**North Boambee Subdivision (MP 05_0129 Mod 3)
Request for Additional Information**

Notification of Modification – Lakes Estate Residential Subdivision (MP 05_0129 MOD 3)

Development Application; Section 4.55 (1A) Modification of Consent MP 05_0129 to Stage 3A, Lot 10 DP 1240161, The Lakes Estate Residential Subdivision, North Boambee Valley, Coffs Harbour City Council Local Government Area.

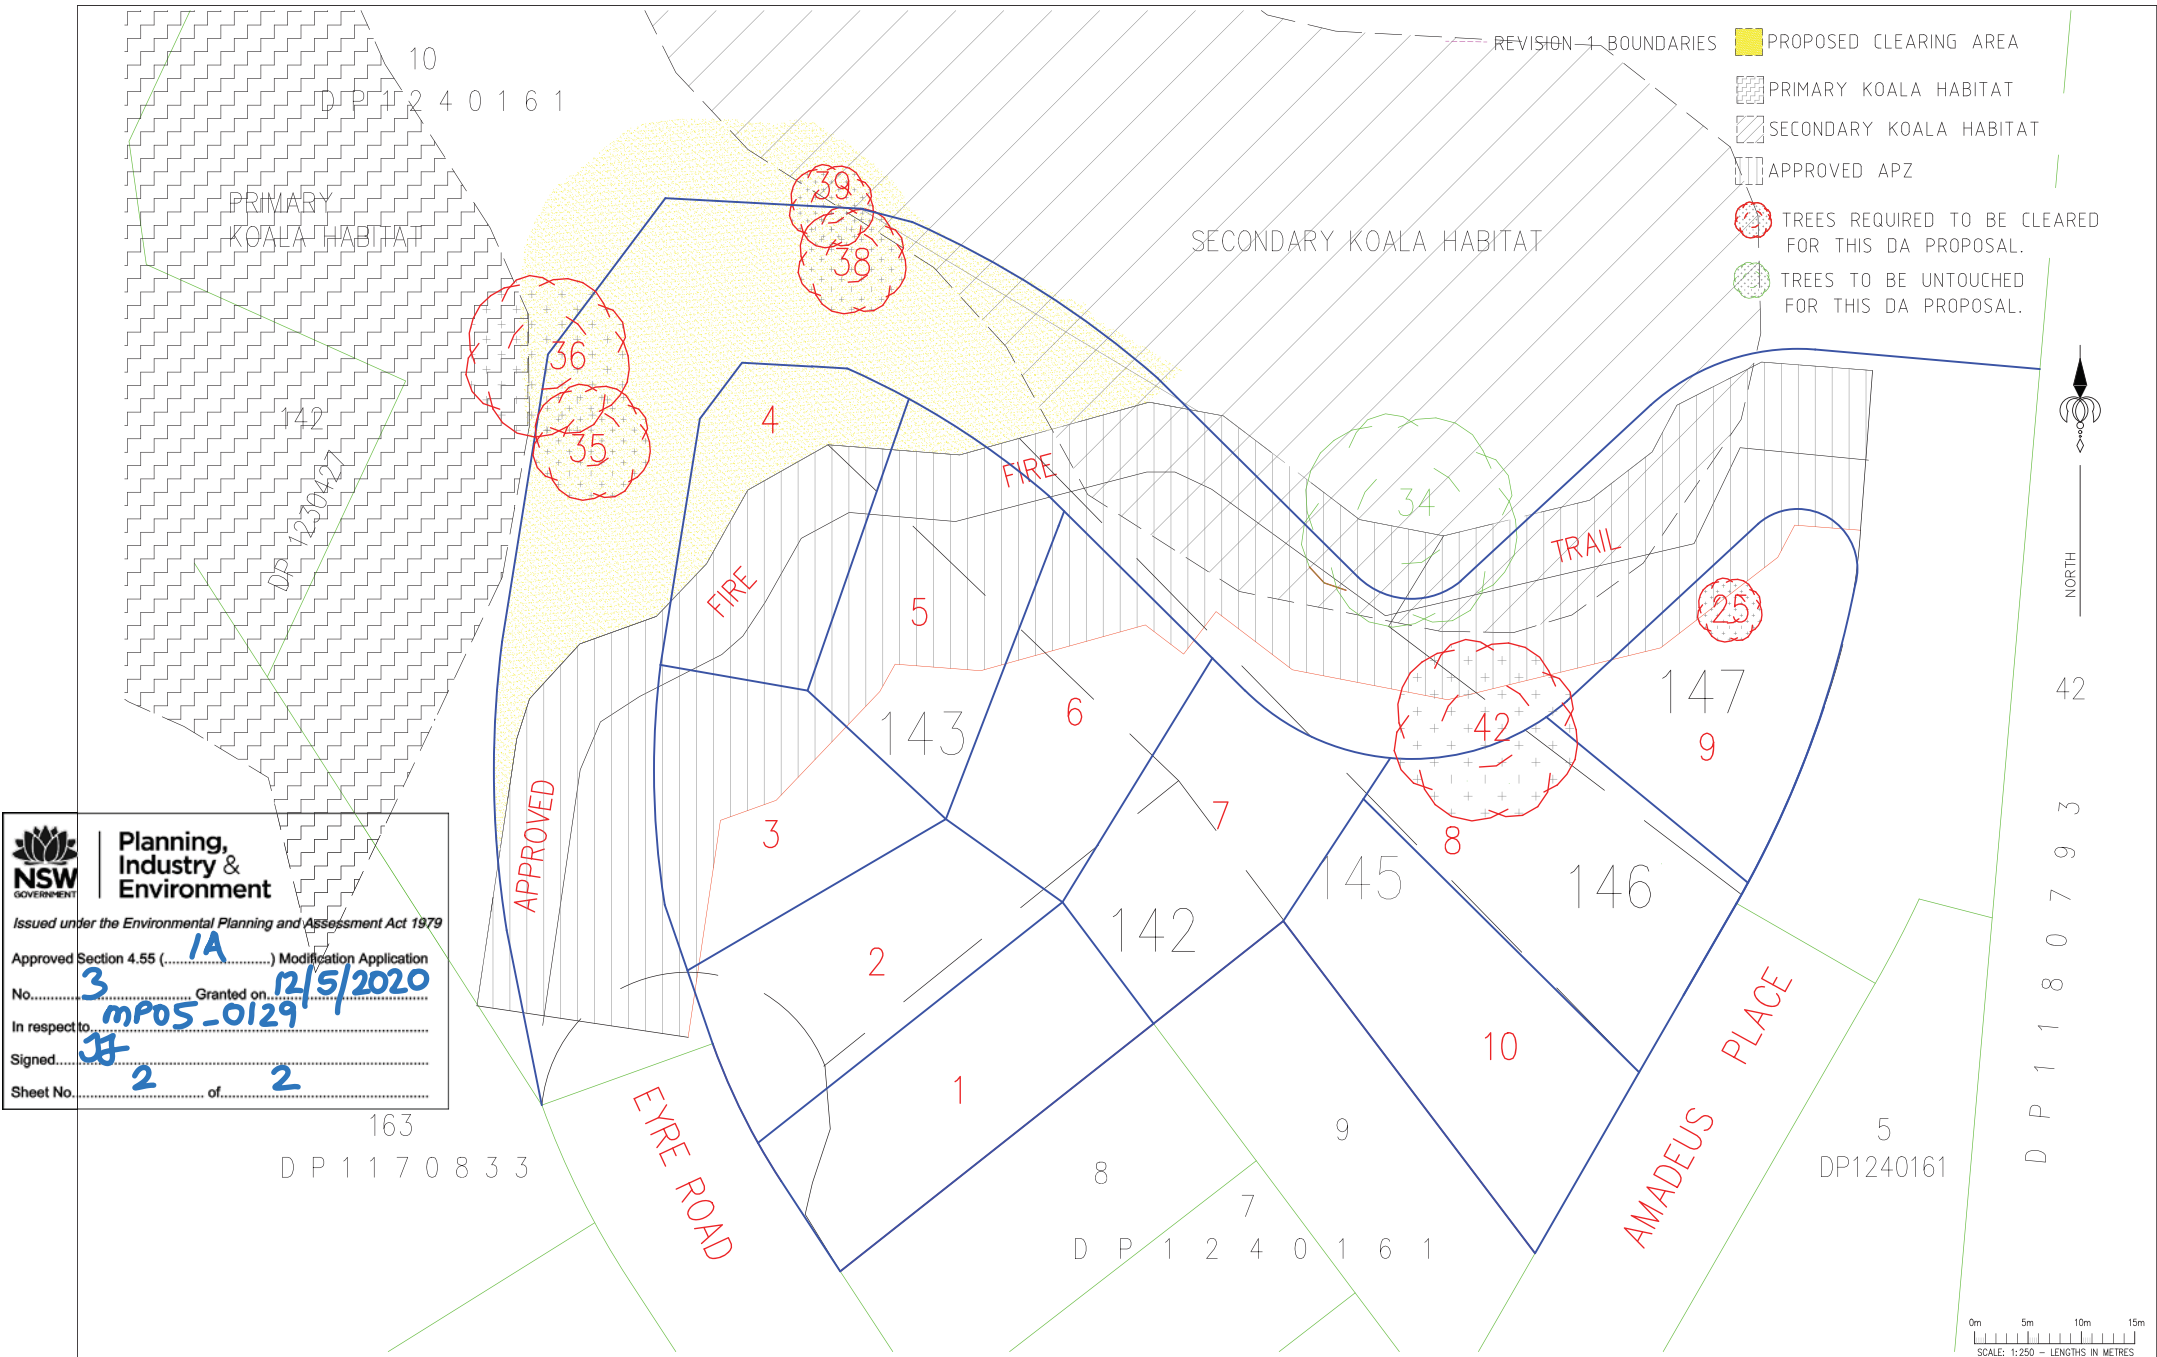
1. The extension of Eyre Road with an 8m wide carriageway in accordance with Section 4.1.3 of Planning for Bushfire Protection 2006
2. Removal of the extension of Road No. 1 to the north
3. The location of the proposed retaining walls.

- It is noted that the proposed road width does not comply with Planning for Bushfire Protection 2006, which requires a minimum width of 8 metres, as specified in Section 4.1.3. It is recommended that this matter be raised with the NSW Rural Fire Service and that the applicant be asked to amend their plans to demonstrate compliance with this requirement.

- The submitted plans show Road no.1 being extended to the north. Council does not support this, given that this extension does not service an approved residential area to the north and that this extension creates an intersection, which may not comply with required sight distances and grades. It is requested that the applicant be asked to remove this northern extension of Road no.1.

- Sheet 4 of the submitted plans shows retaining walls at the boundary. It is unclear, however, whether these walls are proposed to be located on private property or the road reserve. In this regard, Council will not agree to retaining structures being located within the road reserve. It is requested that the applicant be asked to clarify (on plan) where the proposed structures sit.
